M60/M62/M66 Simister Island Interchange

TR010064

7.24 WRITTEN SUBMISSIONS FOLLOWING NOVEMBER HEARINGS AND RESPONSES TO ACTION POINTS FROM CAH1 AND ISH2

December 2024

FIGURE 2.3

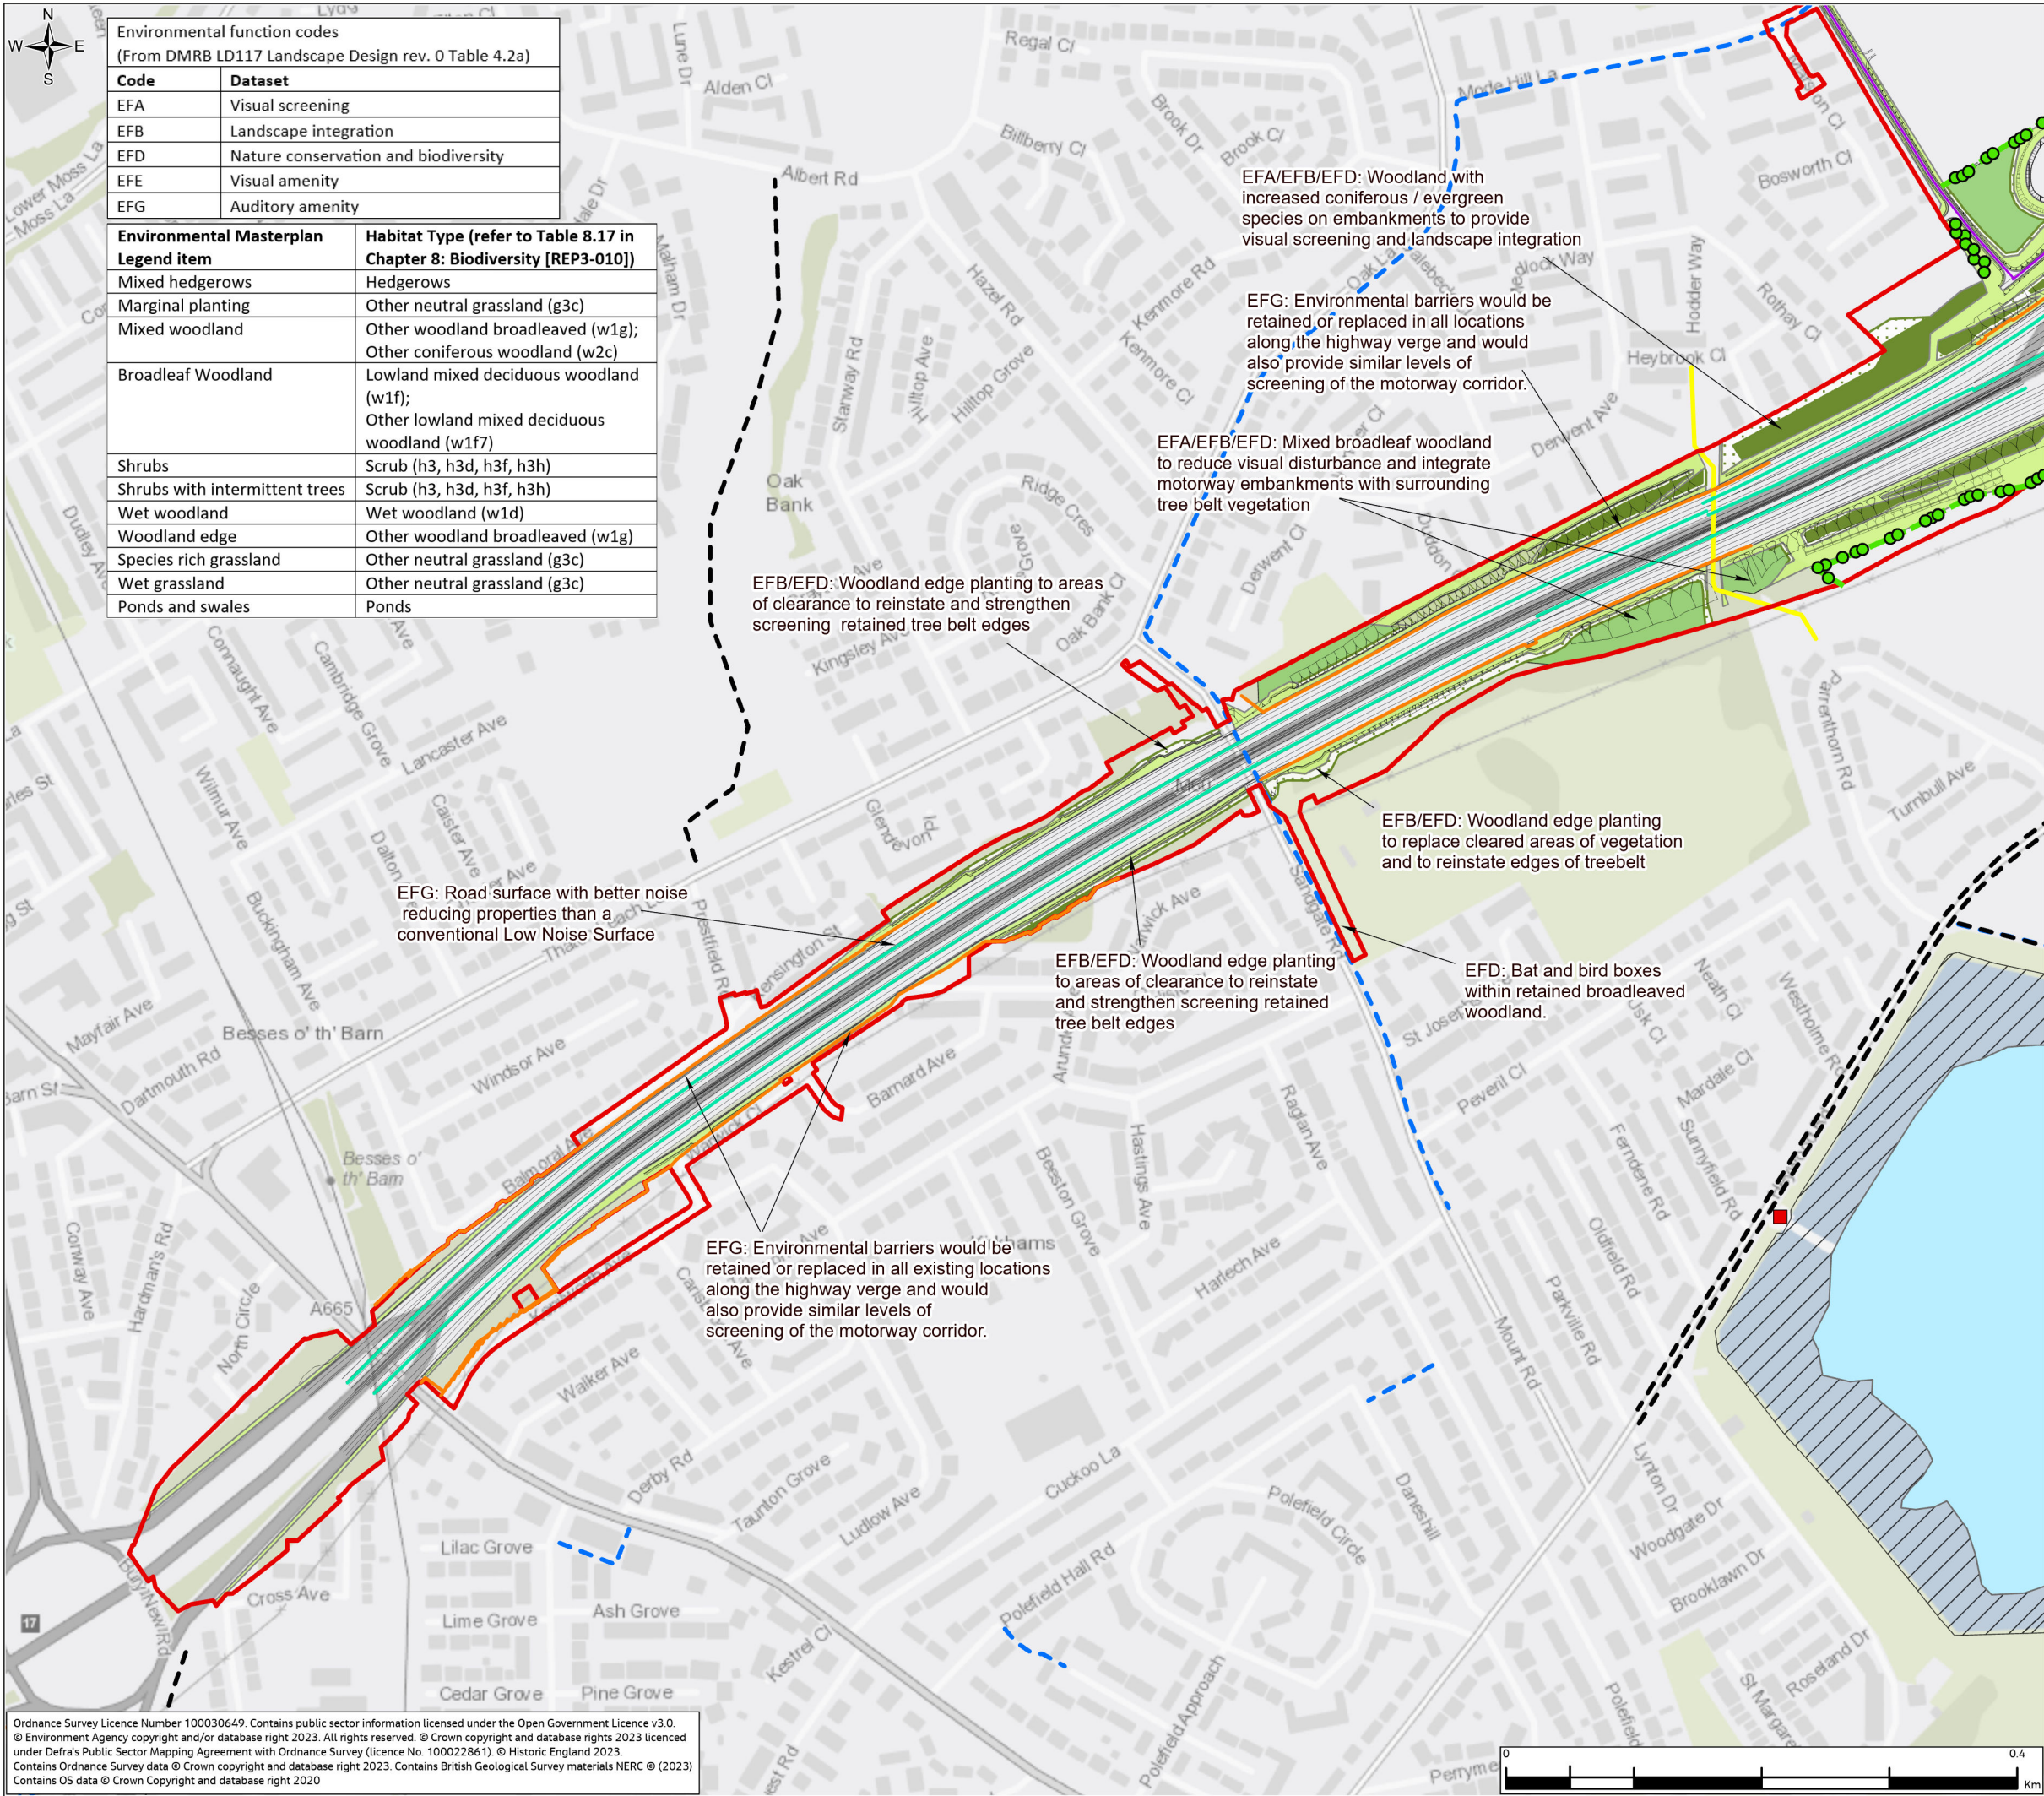
9	Explain why, when the design review panel "strongly encouraged the design team to introduce more trees across the Scheme", this was not included within the proposed design and was not considered feasible, notwithstanding your comments in Table 4-2 row 8 in the Scheme Design Report [APP-151].	The Applicant	D4	<p>The Design Council's comment needs to be understood in context. The Design Council review occurred at an early stage of the development of the preliminary design of the Scheme. Landscaping design ordinarily occurs towards the end of the design programme, once elements such as earthworks and the overall understanding of the Scheme design "footprint" are known. This is to avoid abortive design work and re-work on elements of the design that might end up being removed from the Scheme design prior to the final environmental impact assessment and DCO application.</p> <p>The Applicant has reviewed the statutory consultation materials used (as shown in Annex L of the Consultation Report [APP-033]), and the presentation to the Design Council review meeting, which showed screenshots of the draft Environmental Masterplan provided in the Preliminary Environmental Impact Report (provided in Annex L of the Consultation Report [APP-033] and the Scheme visualisation used during the Design Council presentation and Statutory Consultation.</p> <p>At that time, the Scheme visualisation did not show or illustrate any landscape planting for the reasons cited above; Scheme visualisations require a 3D model of tree planting and this had not been developed. Therefore, the Design Council comment related to tree planting, was made at a point when there was an absence of landscape planting from the Scheme visualisations.</p> <p>In response to Statutory Consultation and after the point of engagement with the Design Council, several areas were subsequently removed from the Scheme. For example, the area north of the M60, west of Junction 17 where Pond 6 was located, the area west of pond 5, south of J18 and the area to the far north and east of the northern loop were removed. Details of these changes can be found in Table 5-14 of the Consultation Report [APP-021] and by comparing the Land Plans [REP3-004] with Map Book 2 – Land Use Plans used at Statutory Consultation which are provided in Annex L.9 of the Consultation Report [APP-033]. The overall reduction in area meant that tree planting opportunities were reduced in comparison to the point when the Design Council provided its observations.</p> <p>The Applicant considers that the volume of replacement tree planting is proportionate to the loss and is balanced against the environmental mitigation requirements of the Scheme. The quantum of trees shown within the landscape proposals also reflects the physical and geo-physical constraints of the Scheme area, specifically along the M60 corridor between J17 and J18 of the M60 which is particularly constrained. The presence of buried services such as statutory undertaker apparatus and drainage infrastructure also limit tree planting along their respective corridors due to the risk of root ingress and potential restrictions for future maintenance access.</p> <p>As outlined in Table 4-1 of the Scheme Design Report [APP-151], the landscape design and planting design fits into the context of the Scheme. Specifically, the Scheme landscaping has taken the Bury Unitary Development Plan (UDP) land use designations into account including Bury UDP Policy Env 9/1 Special Landscape Area and the Green Belt. For example, carefully designed groups of trees and shrubs to help integrate into the surrounding vegetation pattern. Particular attention has been given to avoid, reduce or remediate (offset) potential effects on the Special Landscape Area. Mitigation</p>

16	Review what is included within the proposed Scheme in respect of safety measures for footpath 9WHI and whether any planting/screening from the motorway for mitigation is included, or could be included, which could be considered an enhancement	The Applicant	D4	<p>The Applicant confirms that, as shown on the General Arrangement Plans [APP-005] between chainage 2210 (where the diverted Public Right of Way (PRoW) (9WHI)) connects to the existing alignment and chainage 2020, the PRoW is at the top of a cut slope (i.e. above the new M66 southbound diverge), following this, the new M66 southbound diverge transitions to embankment. As such, during the detailed design, a detailed assessment of risk will be undertaken that considers the proximity of the PRoW to the M66 Southbound diverge link and the height of embankment to determine whether a safety barrier will need to be installed and, if so, over what longitudinal distance.</p> <p>Where a safety barrier is required on the approach to the Pike Fold Bridge, it will connect to the parapet of the new Pike Fold Bridge and this combination of safety barrier and bridge parapet will ensure that vehicles cannot deflect down and onto the PRoW. A Stage 2 Road Safety Audit will be undertaken at the detailed design.</p>

Action	Description	Action by	When	Applicant Response & Summary of Action taken
				Figure 2.3: Environmental Masterplan, of the Environmental Statement Figures [APP-057] shows the proposed mitigation planting, secured through Requirement 5 of the draft DCO [REP3-006]. In this area mitigation planting, consisting of native woodland, native shrub and intermittent tree belts, is proposed on the embankments of the Northern Loop and M66 southbound diverge link to both integrate the earthworks and provide screening of traffic in wider views from the east, including the PRoW. Hedgerow planting, along the diverted section of footpath 9WHI is provided adjacent to balancing pond 1 to link the field patterns and also provide immediate screening for closer range views once established. The majority of planting areas are of a suitable size (over 5m width) that once established should provide adequate screening of views from a user of footpath 9WHI to the M66 and most of the northern loop traffic. North of where the diverted section of footpath 9WHI connects to the existing alignment, views will be as they are presently.
